From: Miriam Nicholls
Sent: 02 November 2017 12:05
To: Planning.Responses
Subject: RE: Planning Consultation on: BR/218/17/PL

NOTIFICATION FROM ARUN DISTRICT COUNCIL
Town & Country Planning Act 1990 (as amended)
Town and Country Planning (Development Management Procedure)
(England) Order 2015
Planning Permission
APPLICATION **BR/218/17/PL**
NO:
Registered: 26th October

2017
Site Address: 12 London Road Bognor Regis PO21 1PY
Grid Reference: 493599 99152
Description of Works: Creation of ground floor entrance to the rear;
formation of 4No. new two bed flats at first floor level

EXISTING FLOOR PLANS
AND ELEVATIONS

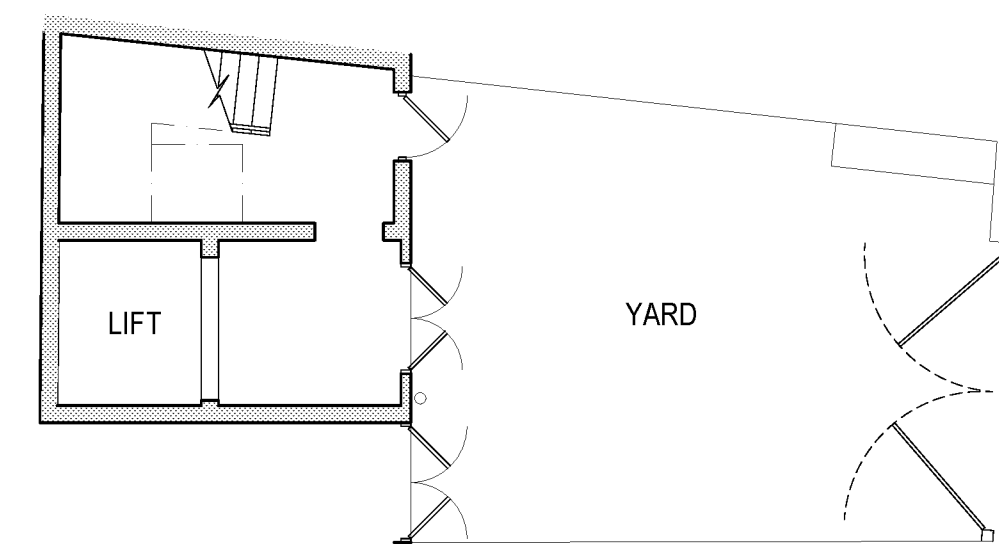
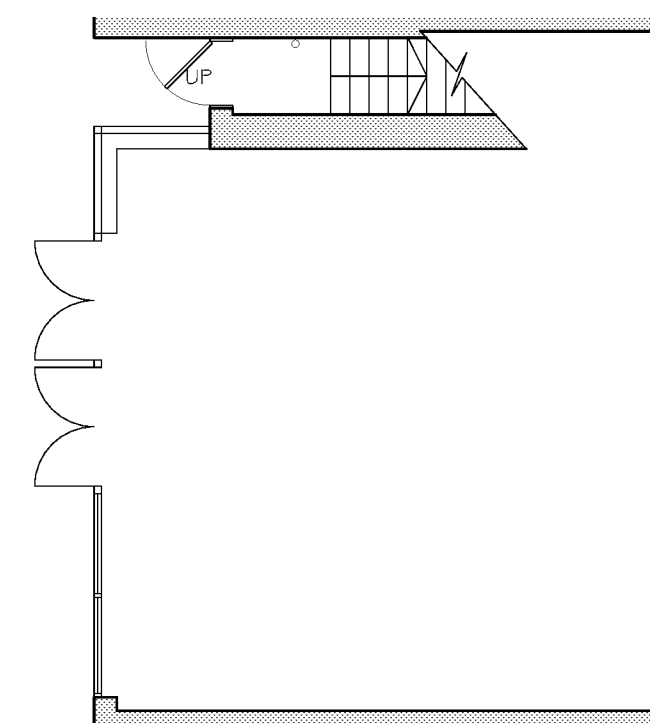
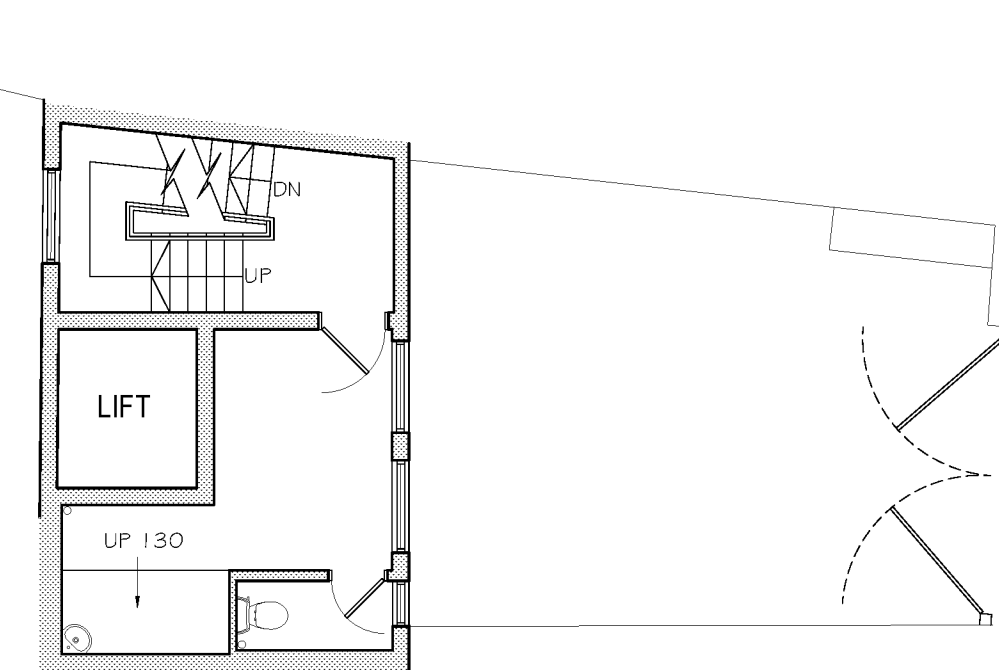
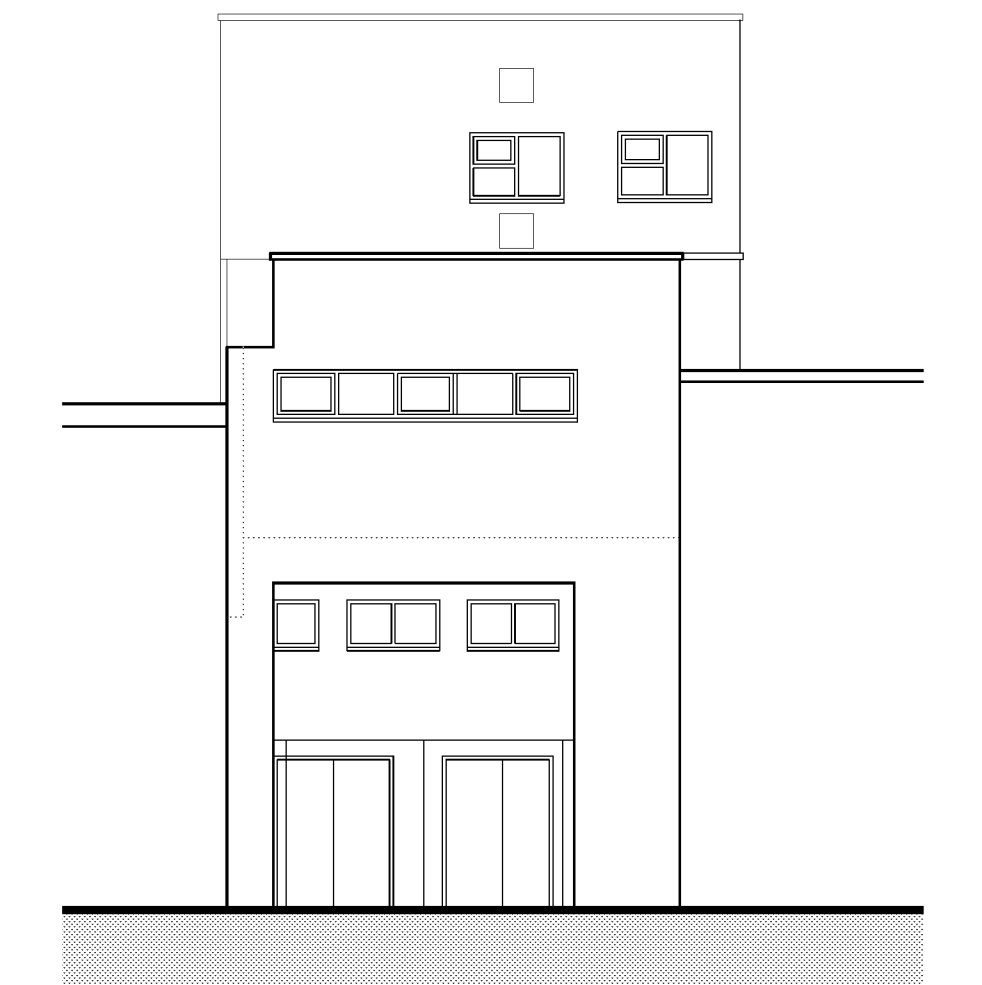
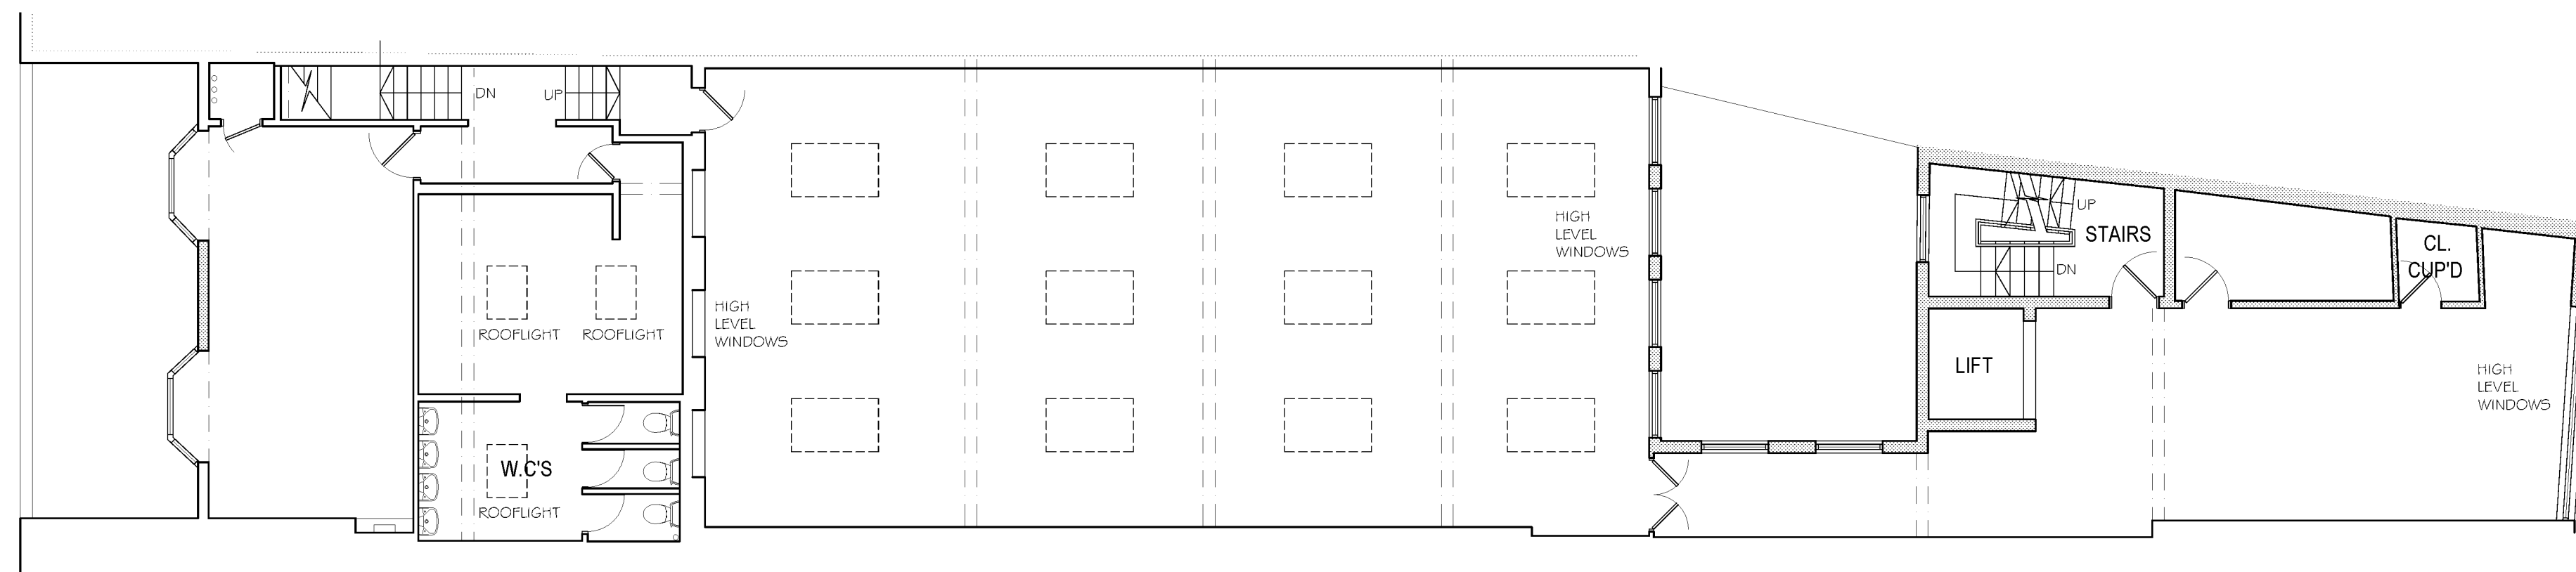
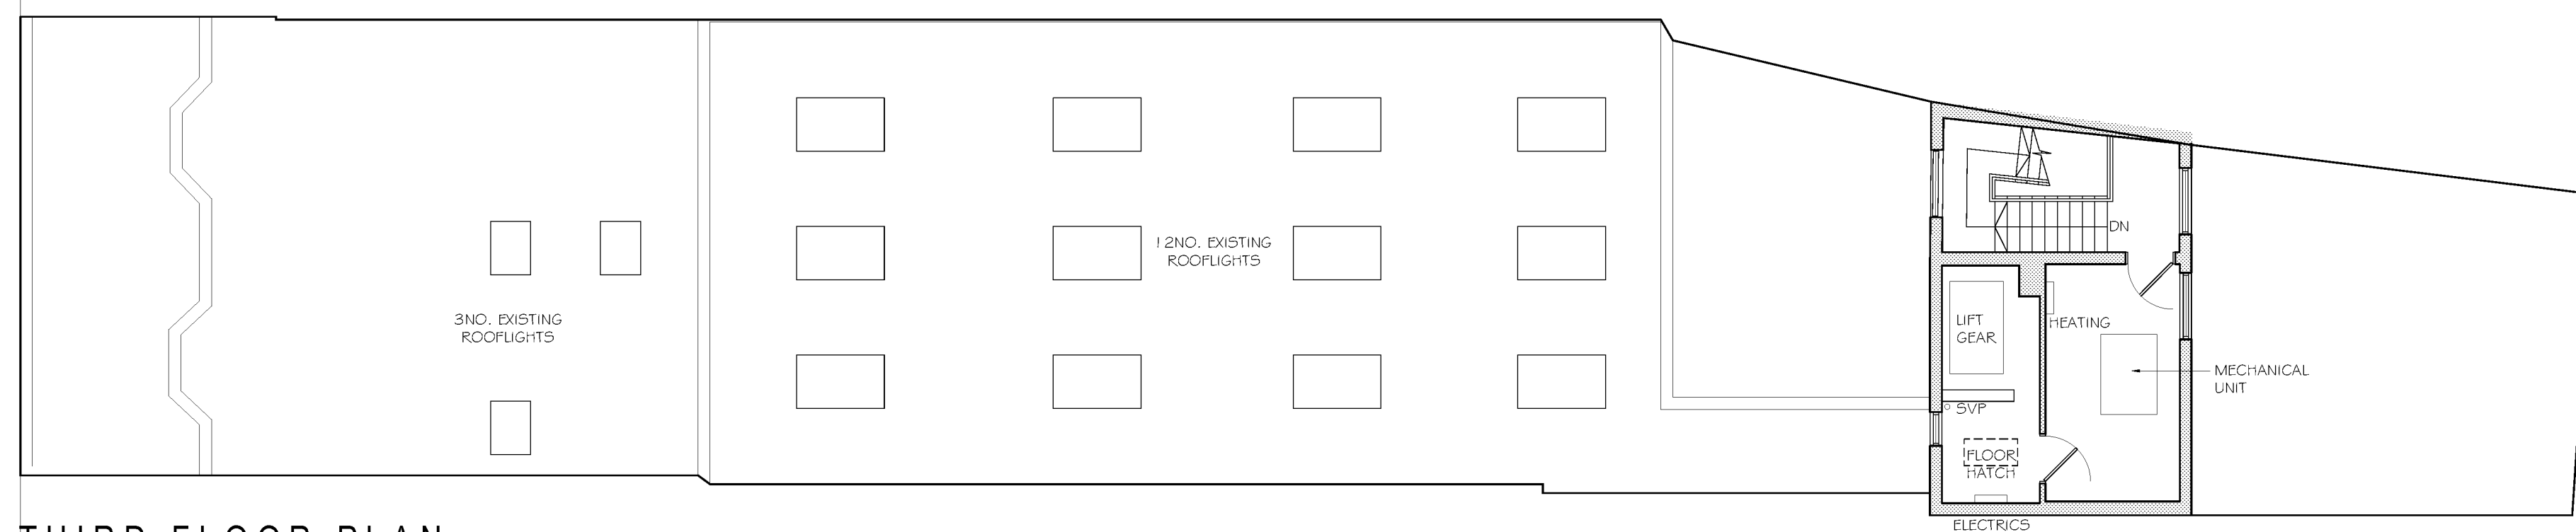
Economic Development are keen to support proposals that bring additional accommodation to the area and potential footfall to town centres. However, we consider it critical that this should not be to the detriment of existing businesses and from the submitted plans we are unable to see how the existing retail unit will be serviced in terms of toilet facilities and storage. If these matters are suitably resolved we would have no objection to this application.
